Recommendation Report for Planning Permission for Works or Extension to a Dwelling

REF NO: AB/46/18/HH

LOCATION: 3A Fitzalan Road
Arundel
BN18 9JP

PROPOSAL: Single storey front, side & rear ground floor extension & loft conversion with associated drainage works (resubmission following AB/70/17/HH).

GROUND FLOOR PLAN
AS PROPOSED
1:50

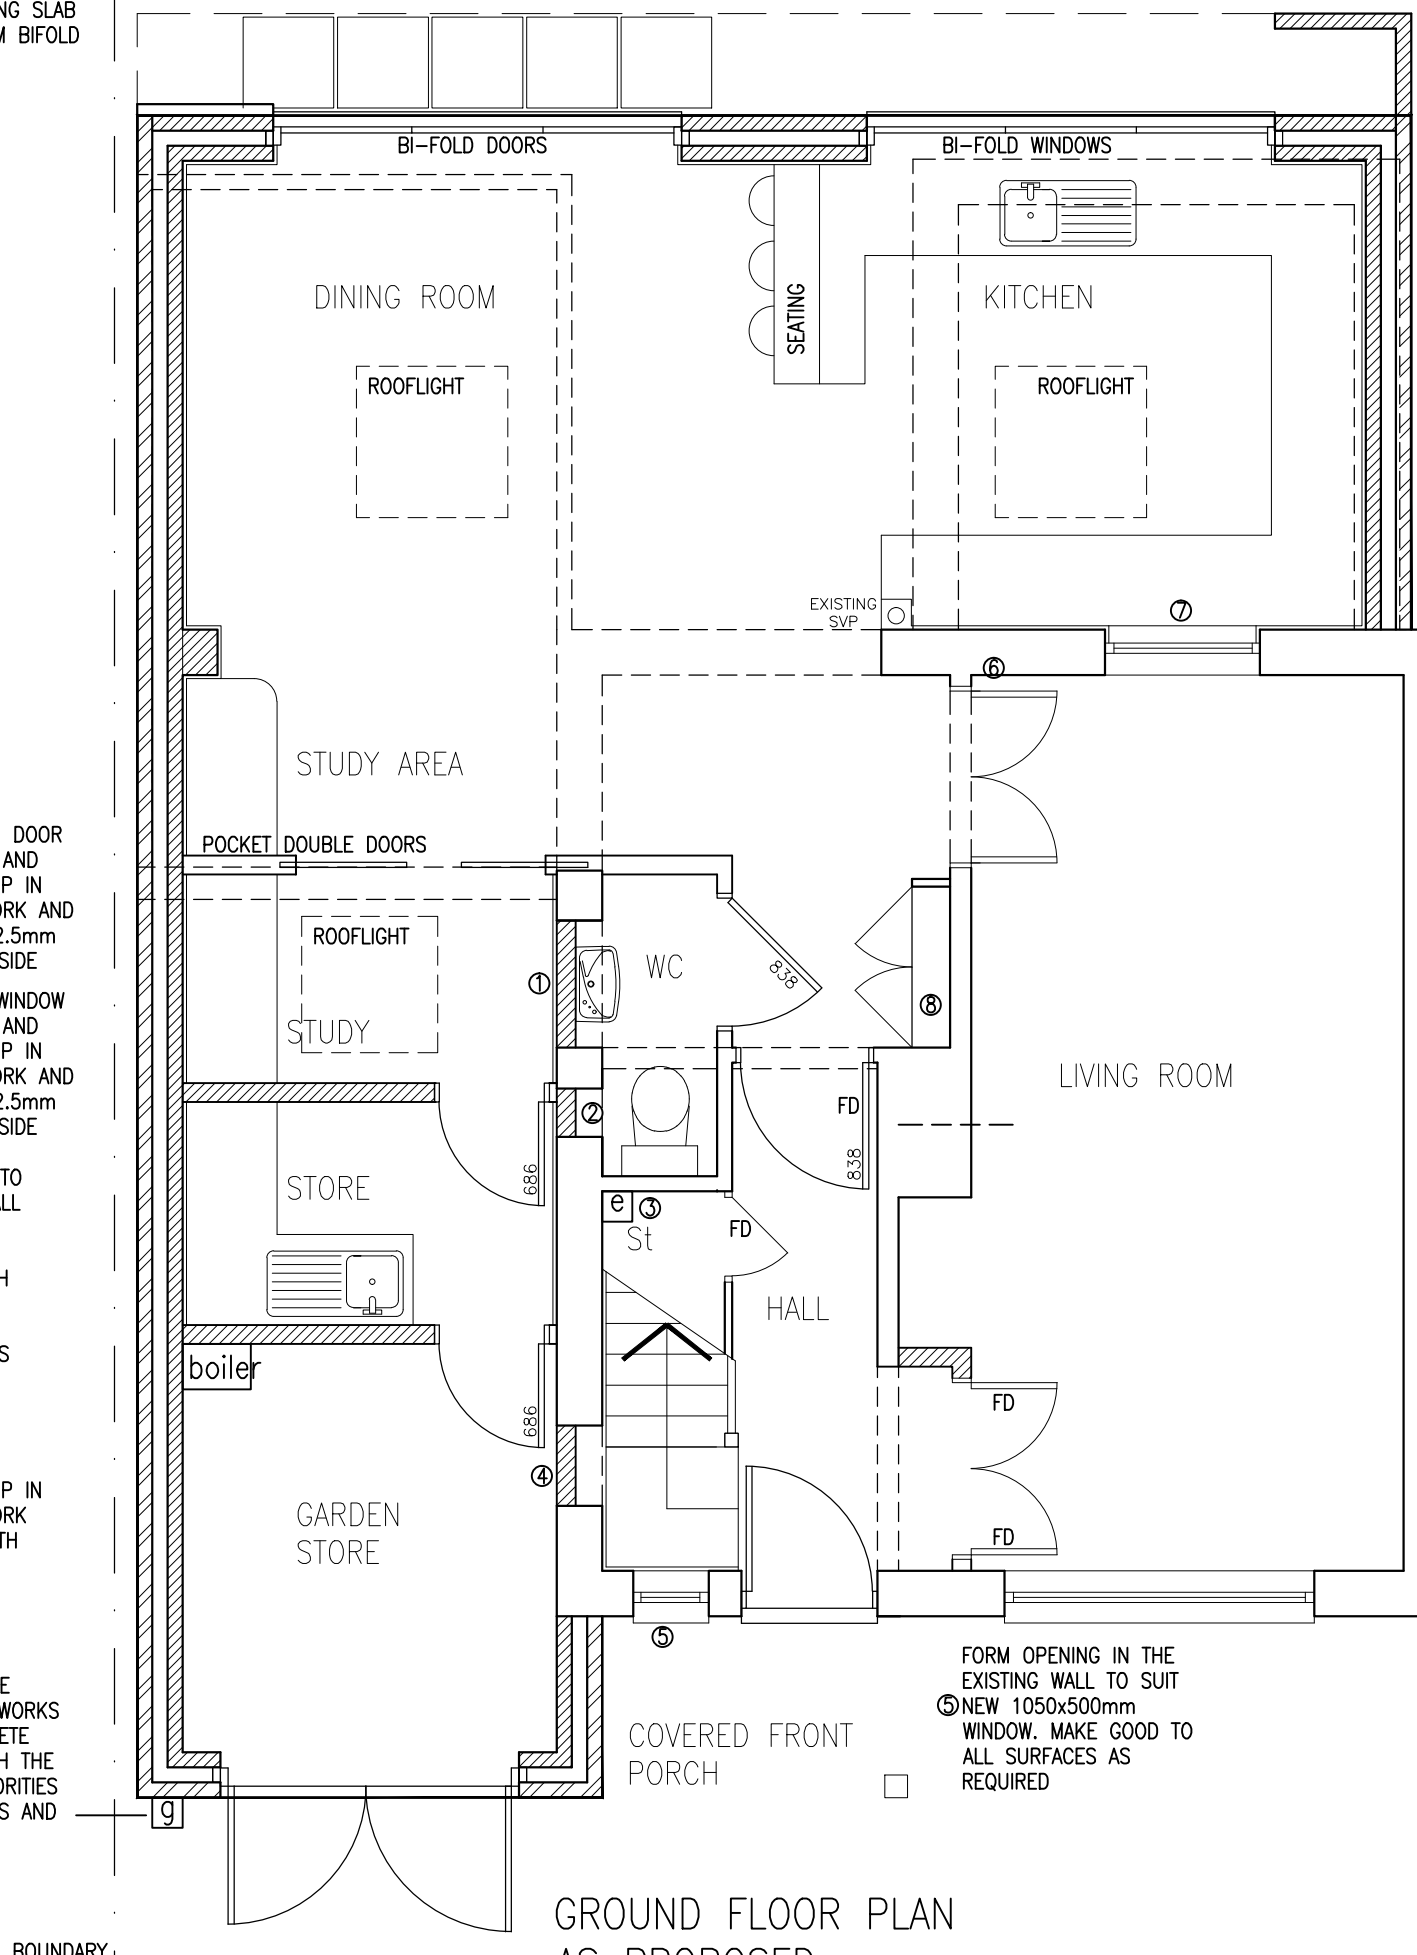
The proposed L-shaped wraparound extension includes a front projecting element. From an assessment of the plans it is noted that the front projecting element would have a depth of 1.2 metres 3.4 metres in height to the top of the proposed dummy pitched roof. From the Officer's site visit it was noted that there are other front projecting elements along Fitzalan Road. Officers consider that the proposed L-shaped wraparound extension would be of an appropriate size and scale.

3 rooflights are proposed into the flat roof of the proposed single storey wraparound extension. From an assessment of the plans the rooflights would simply allow light into the extension and would provide views of the sky.

The proposed side and rear projecting elements of the wraparound would be set in from the common boundary of adjoining property number 3 by approximately 0.15 of a metre and the side elevation of adjoining property number 3 by 2.59 metres at its maximum (to front) and 1.8metres at its minimum (to rear). The wraparound extension would have a height of 2.9 metres, which would be .7 of a metre higher than the existing flat roofed garage with a height 2.2 metres. There are a number of windows in the side elevation of adjoining number 3 and there is a conservatory to the rear. Having regard to the height of the proposed extension and the aforementioned separation distance it is noted that some loss of light would occur, however it is considered that it would not be such as to warrant refusal. Additionally officers note that the conservatory at adjoining property number 3 features glazing on all sides.

The proposed rear extension would have an approximate depth of 4.05 metres, while the existing rear conservatory has a depth of 3.15 metres. From the officers site visit it was noted that there is a single storey rear extension to the rear of adjoining property 3b which, also having regard to aerial photography, appears to be of a similar depth to that of the existing conservatory at the rear of the application dwelling. Therefore, officers do not consider that the increase in height and the additional depth, of approximately 0.9 of a metre would have a detrimental impact upon the occupiers of adjoining properties in particular those at 3b.

Currently there is space for the parking of 2 cars in front of the existing garage and garage parking. With no on road parking restrictions. The applicant has confirmed on the submitted application form that the proposed works would not affect the existing parking arrangements. From an assessment of the plans the proposal would impact on current off-road parking levels, as it would lead to the removal of the existing garage and an would bring the built form further forward into space that is currently available for the off-road parking of vehicles. Officers note that while this is not ideal, many properties along Fitzalan Road do not have off-road parking and utilise the unrestricted on road parking.

West Sussex County Council guidance on parking provision requires 2 parking spaces to be provided. From the submitted plans and Officer's site visit only one off-road parking space space would be able to be provided as a result of the proposals. However, Officers do not consider the impact of 1 off-road parking space being displaced to the highway would lead to highway safety issues which would warrant refusal .

LOFT PLAN
AS PROPOSED
1:50

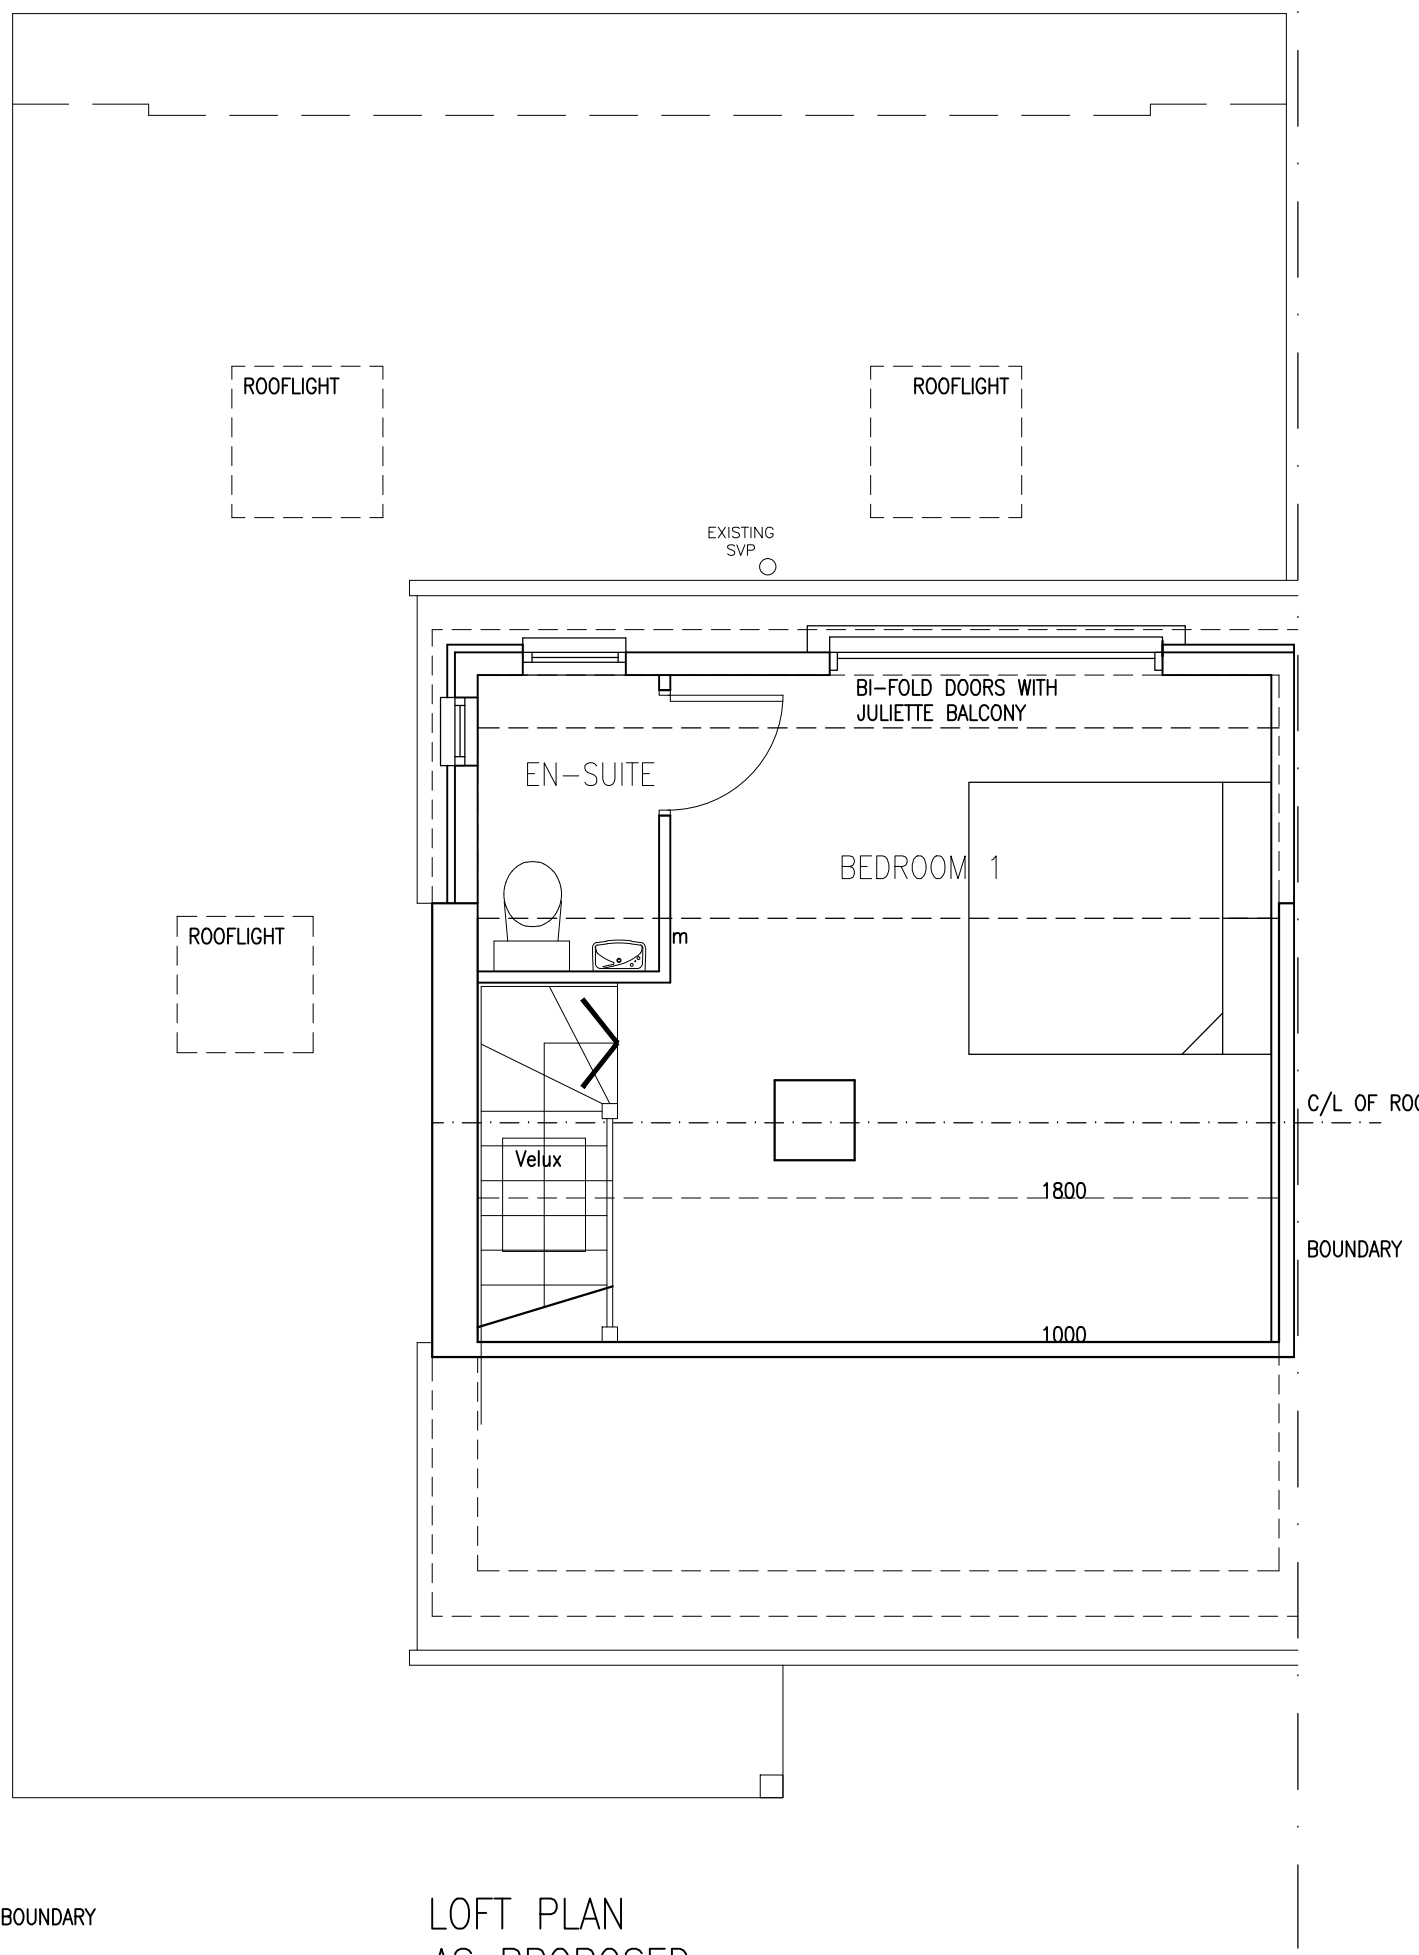
Permission is sought for the erection of a rear dormer window and a single storey, L-shaped side, rear and front wraparound extension. The proposed rear dormer would measure approximately 5.5 metres in width, 2.9 metres in depth and 2.5 metres in height. The proposed dormer would incorporate a Juliet balcony with folding doors, 1 long window serving the proposed en-suite bathroom into the rear elevation, along with a window into the side elevation, facing adjoining property 3, which would also serve the en-suite bathroom.

While the proposed dormer appears to be large as it would almost fill the rear roofslope, it would only have a volume of 19.94 cubic metres, which is less than the 50 cubic metres allowed under permitted development. From a search of the planning history it is noted that fairly large dormers have been approved e.g. those at 13 Fitzalan road under application ref: AB/108/16/HH. Additionally, when carrying out the site visit the Officer noted a few large dormers that were being constructed to the front and rear of nearby dwellings. Officers consider that the proposed dormer would be of an appropriate size and scale.

With regard to overlooking of adjoining properties 3 and 3b from the proposed dormer window it is noted that when the 45 degree rule is applied some materially harmful overlooking to the primary amenity space would occur. However, from an assessment of the plans and the Officer's site visit it is noted that the level of overlooking that would occur from the proposed dormer window would be the same as the level of overlooking already available from the rear first floor windows which are onto garages and open fields beyond.. The proposed Juliet balcony is noted and Officers do not consider that this would lead to an increased level of overlooking or noise to occupiers of adjoining properties, such that would warrant refusal.

With regard to the side window in the dormer window which would serve the en-suite it is considered that a condition requiring that it be obscurely glazed and fixed shut up to a level of 1.7 metres above the floor of the room which they serve, would be imposed upon any grant of planning permission. As such it is

- 3 The side window serving the proposed dormer en-suite bathroom in the rear elevation shall at all times/be glazed with obscured glass and be permanently non-opening up to a height of 1.7 metres above the floor of the room it serves.

REAR ELEVATION
AS PROPOSED - 1:50

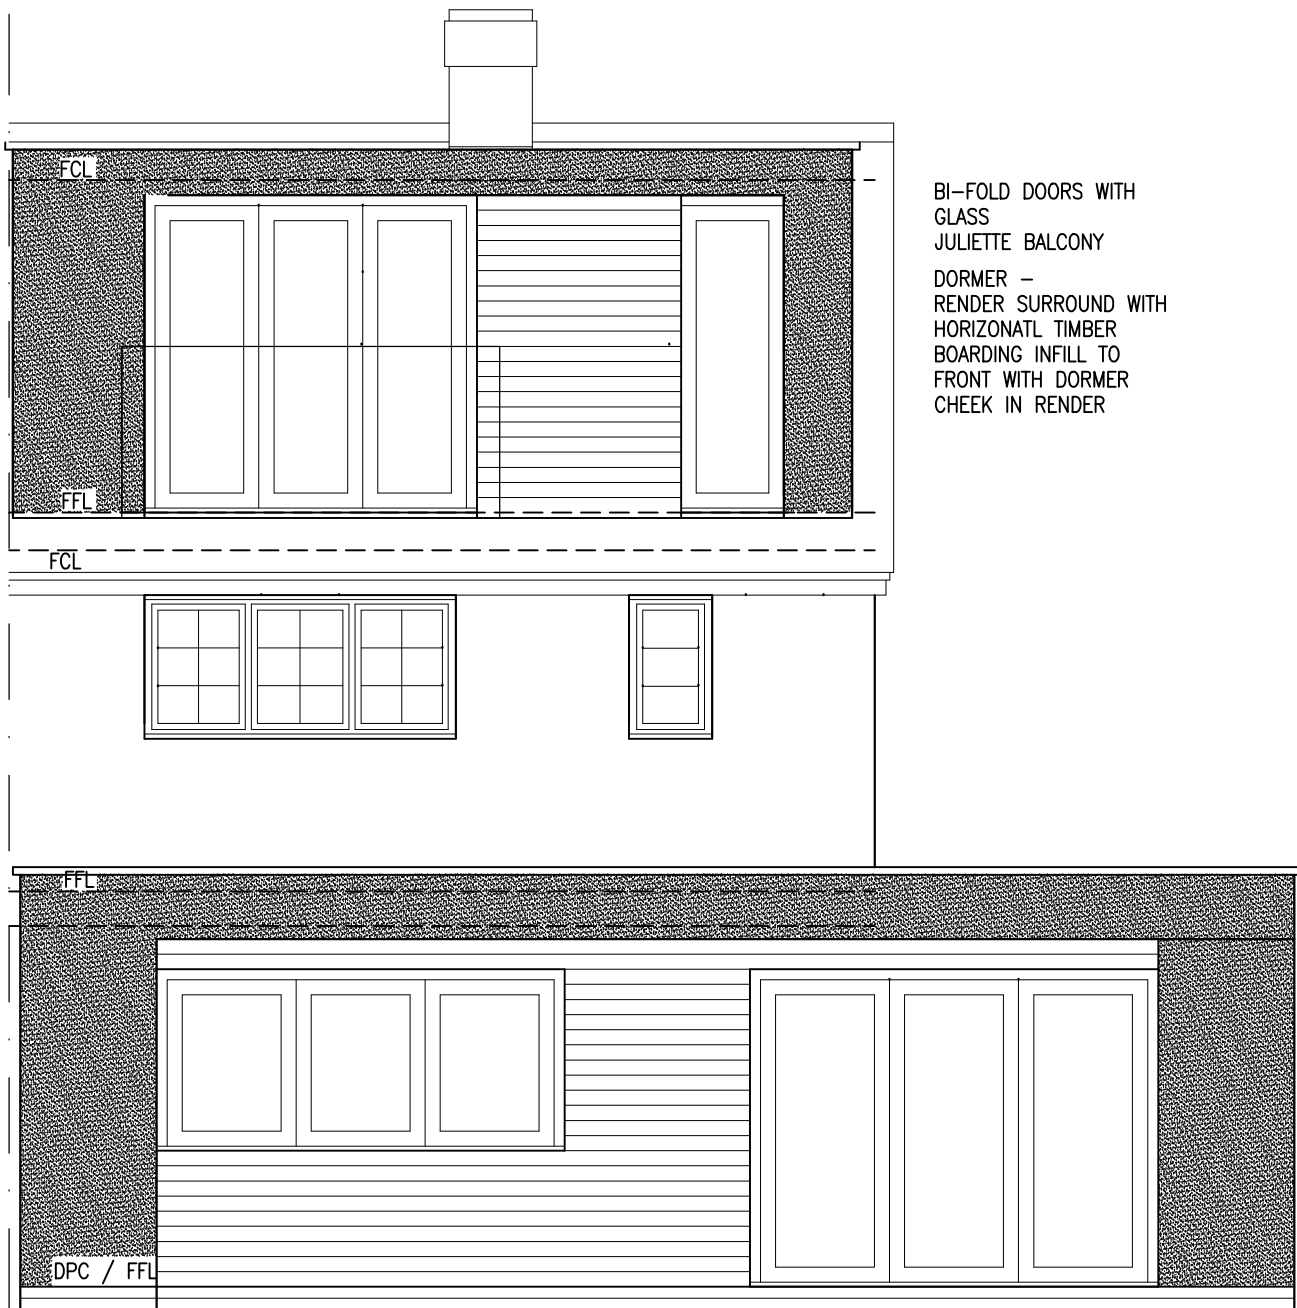
The proposed dormer is to feature:

Render surround.

Horizontal timber boarding infill.

Dormer cheek in render.

Powder coated aluminium bi-fold doors in grey.

From an assessment of the proposed materials it is noted that the materials to be used on the rear dormer and the single storey rear extension element would not match those used in the existing dwelling. Views of the dormer 'cheek' would be available from the highway. Officers note that the dormer 'cheeks (sides)' are to be rendered. Officers consider that while this would not match the application dwelling it would be acceptable and is considered to be a suitable contrast which would not have a detrimental impact on the street scene or the pair of semis which the application dwelling forms part. From the Officer's site visit it was noted that render features within the street scene e.g. adjoining property number 3. It is considered that the, proposed render on the dormer, would provide a interesting contrast to that of the existing building.

No details, such as colour and texture of the proposed render have been provided. A condition requiring details of the proposed materials, to be submitted and agreed in writing with the Local Planning Authority will be imposed upon any grant of planning permission.
